**Consultation Response from: KC Environmental Health (Pollution & Noise Control)**
**2023/91715 - Mohaddis E Azam Education Centre And Masjid E Madani, 225C, Ravenshouse Road, Dewsbury Moor, Dewsbury, WF13 3QU**
**Demolition of existing mosque and erection of mosque and education centre**
**Date Responded:  
13<sup>th</sup> September 2023**
**Responding Officer:  
NH**
**Responding Ref:  
WK/202326609**
**External Artificial Lighting**

### Luminaire layout plan

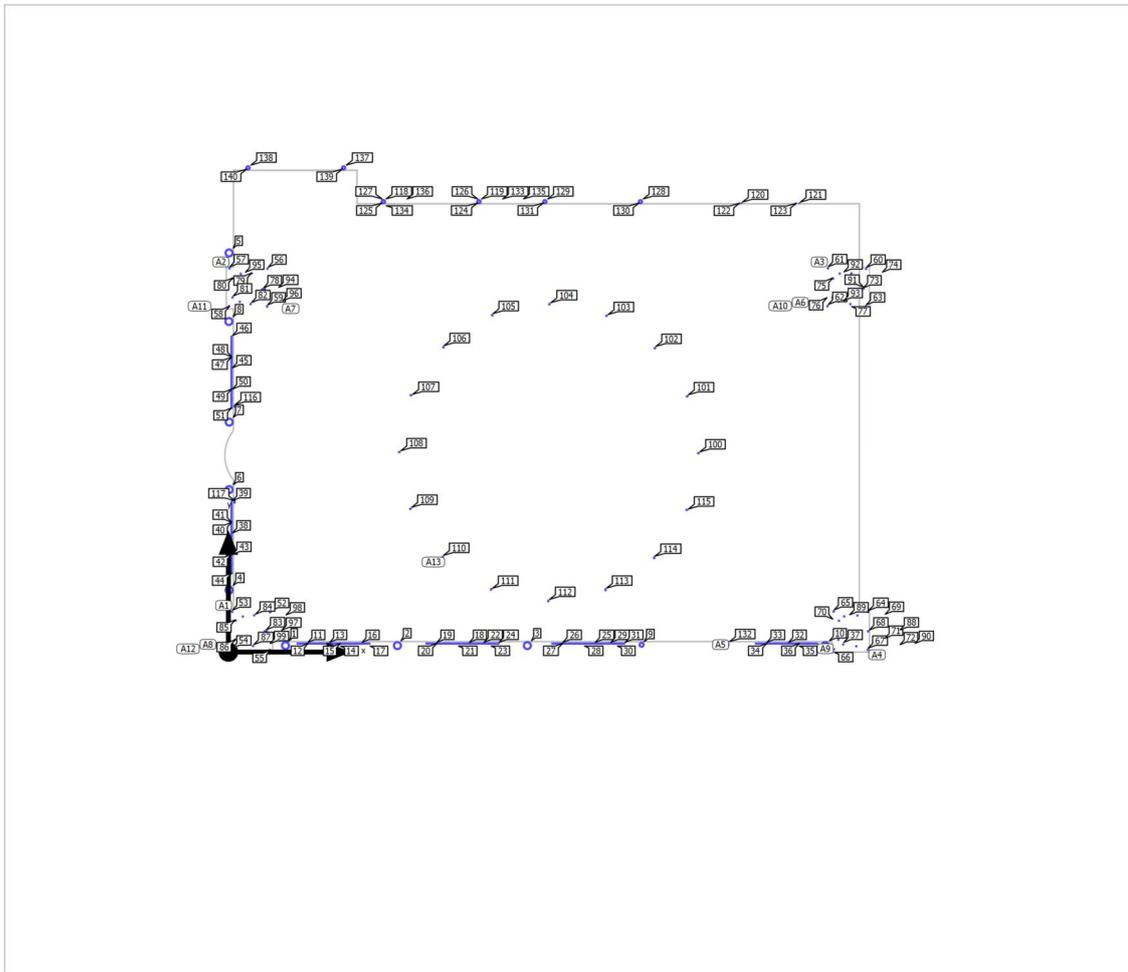
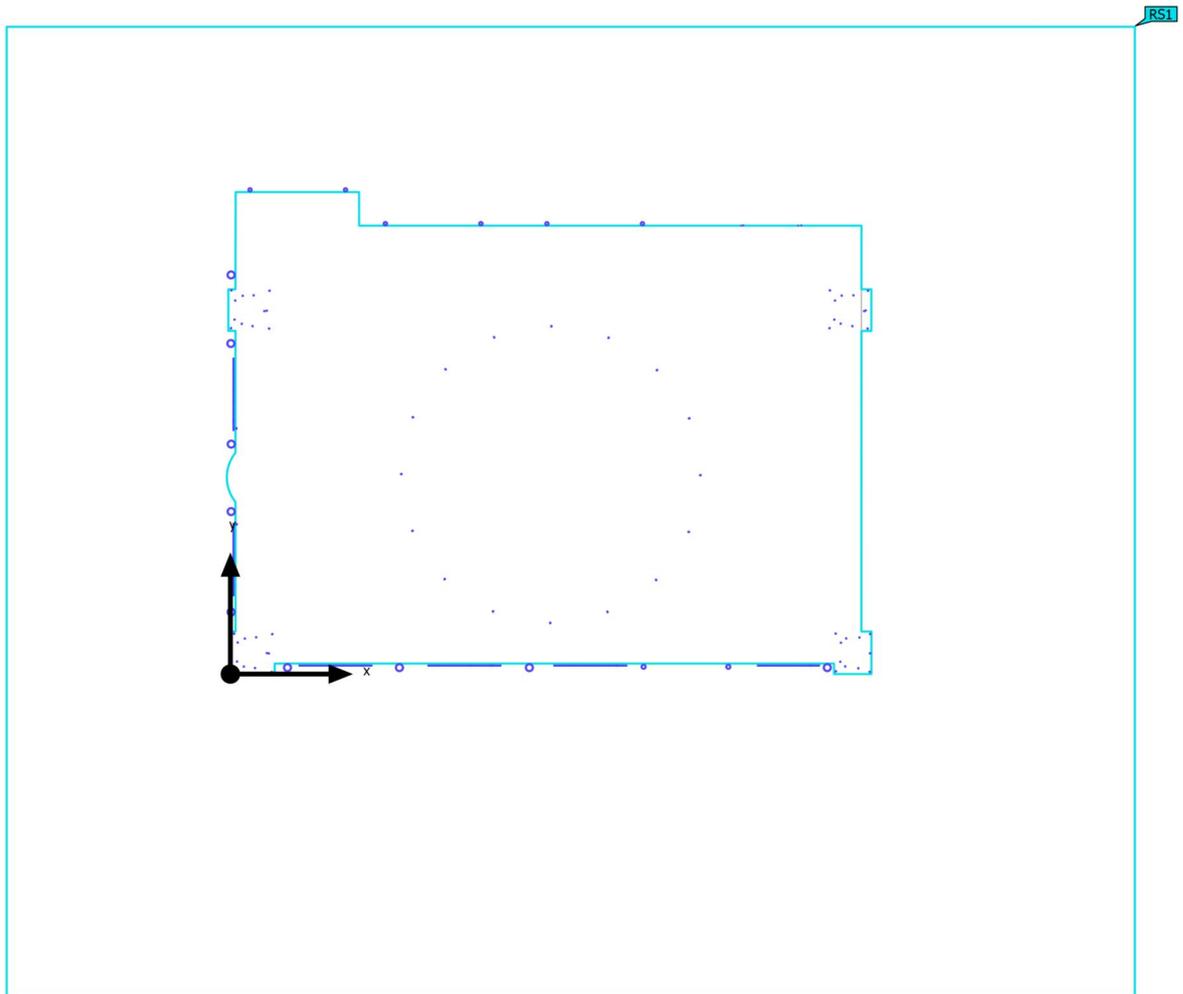
In response to our comments dated July 20th 2023, we have received a Lighting Scheme prepared by cr9edesign (date and referenced not provided). The scheme outlines the intended installation of external artificial lighting at the development. However, upon review, the document lacks crucial information, as follows:

- a) The proposed hours of operation of the lighting
- b) The proposed design level of maintained average horizontal illuminance for the areas that needs to be illuminated.
- c) The measures that will be taken to minimise or eliminate glare and stray light arising from the use of the lighting that is caused beyond the boundary of the site
- d) The methods of switching and controlling the lighting so that it is only operated at the permitted times and at times when it is required.

The proposed design levels of illuminance should be shown to be appropriate for the intended use by reference to appropriate guidance. Generally, to minimise problems of glare and stray light from external artificial lighting it should be installed and maintained in accordance with the "Guidance Note 01/21 for the Reduction of Obtrusive Light" by the Institution of Lighting Professionals: 2021 www.theilp.org.uk. The predicted levels of stray light must not exceed the recommended maximum levels given in Table 2 of this guidance for the corresponding Environmental Zone (i.e. E0 to E4). This should be stated in the supporting information.

Before the installation of external artificial lighting commences a lighting scheme shall be submitted to and approved in writing by the Local Planning Authority. The scheme should include the following information:

- a) The proposed hours of operation of the lighting
- b) The location and specification of all of the luminaires
- c) The proposed design level of maintained average horizontal illuminance for the areas that needs to be illuminated.
- d) The measures that will be taken to minimise or eliminate glare and stray light arising from the use of the lighting that is caused beyond the boundary of the site

- e) The methods of switching and controlling the lighting so that it is only operated at the permitted times and at times when it is required.
